Recommendation Report for Planning Permission for Works or Extension to a Dwelling

REF NO: R/43/21/HH

LOCATION: Iluka
22 Broadmark Lane
Rustington
BN16 2HJ

PROPOSAL: Single store attached garage to side.

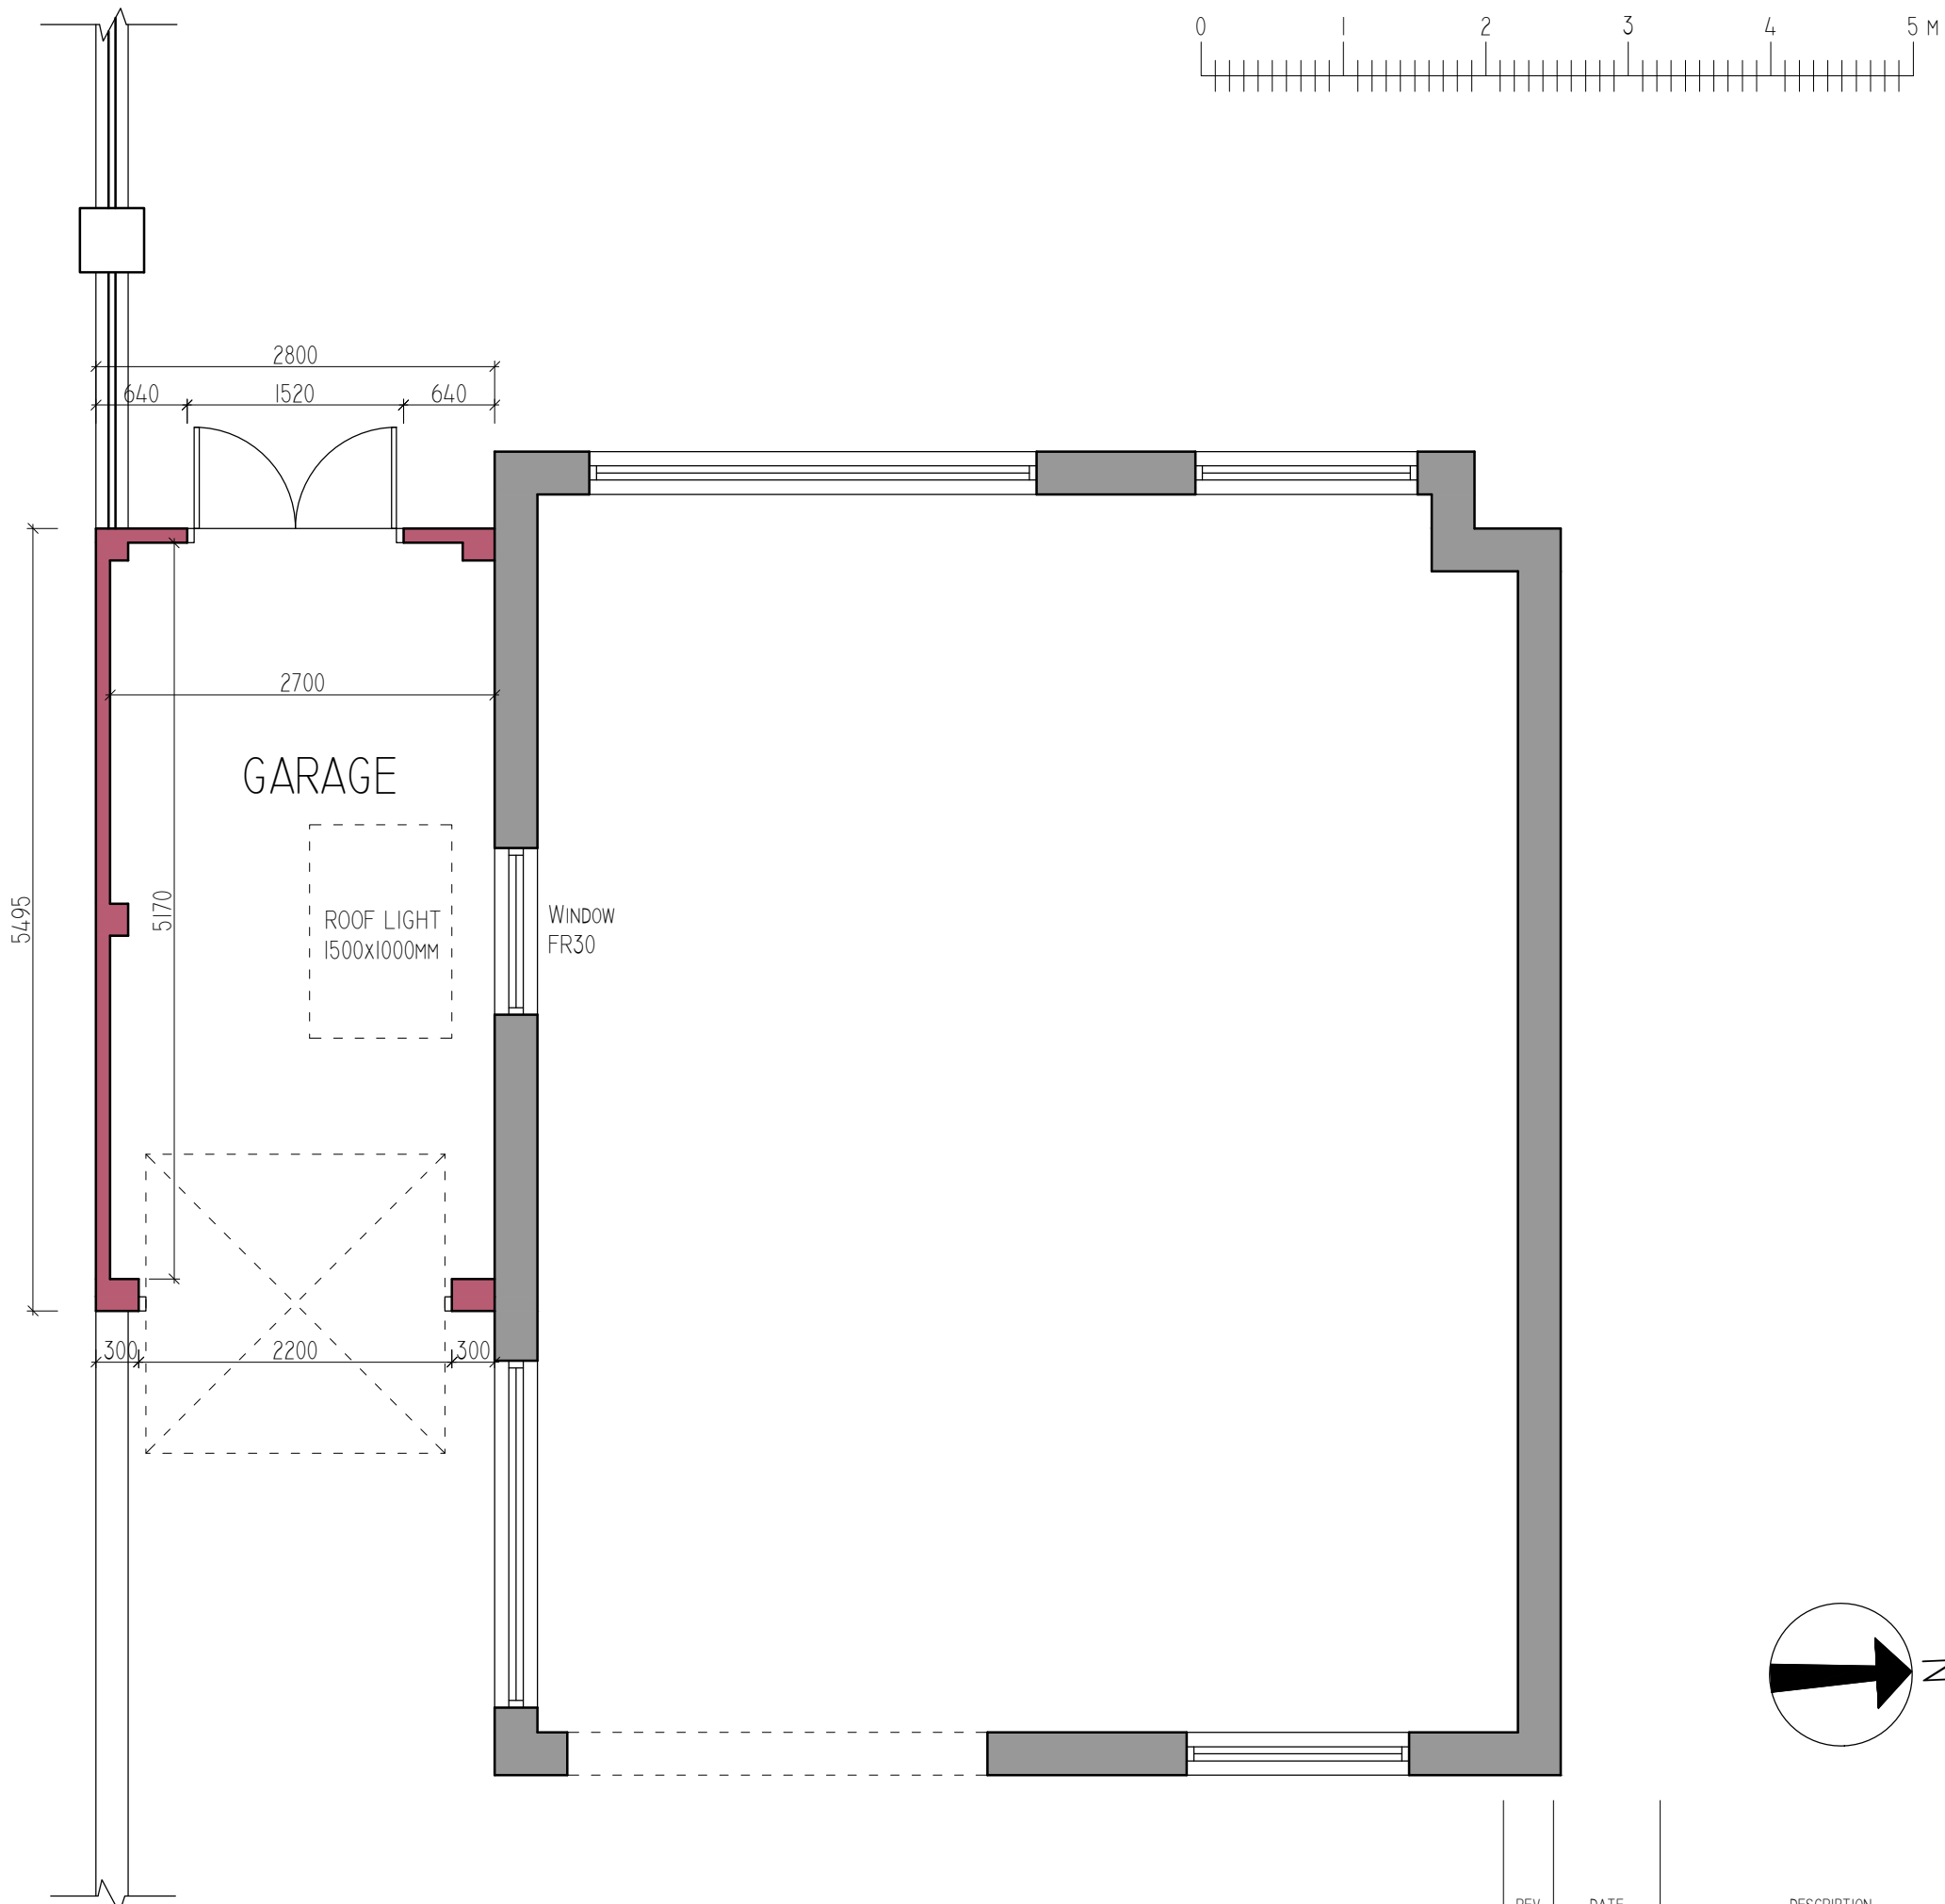
WSCC(ROW/Strategic/Highways): Dimension of the garage does not meet parking standards
LHA does not consider that this proposal would have an unacceptable impact on highway safety or result in 'severe' cumulative impacts on the operation of the highway network, therefore is not contrary to the NPPF (paragraph 109), and that there are no transport grounds to resist the proposal.

The proposal includes erection of single storey garage to the side of the dwelling. The side wall with entrance gate is already in situ. The proposed garage will extend along the high boundary wall by 5.39m in depth and 2.70m high with flat roof.

Highways have been consulted on this application. The dimensions of the garage does not meet the requirements for parking a vehicle. Overall no objection has been raised on the highway safety grounds, Officer response to the comments are that application site already benefits from off street parking and the garage could be utilised for domestic purposes.
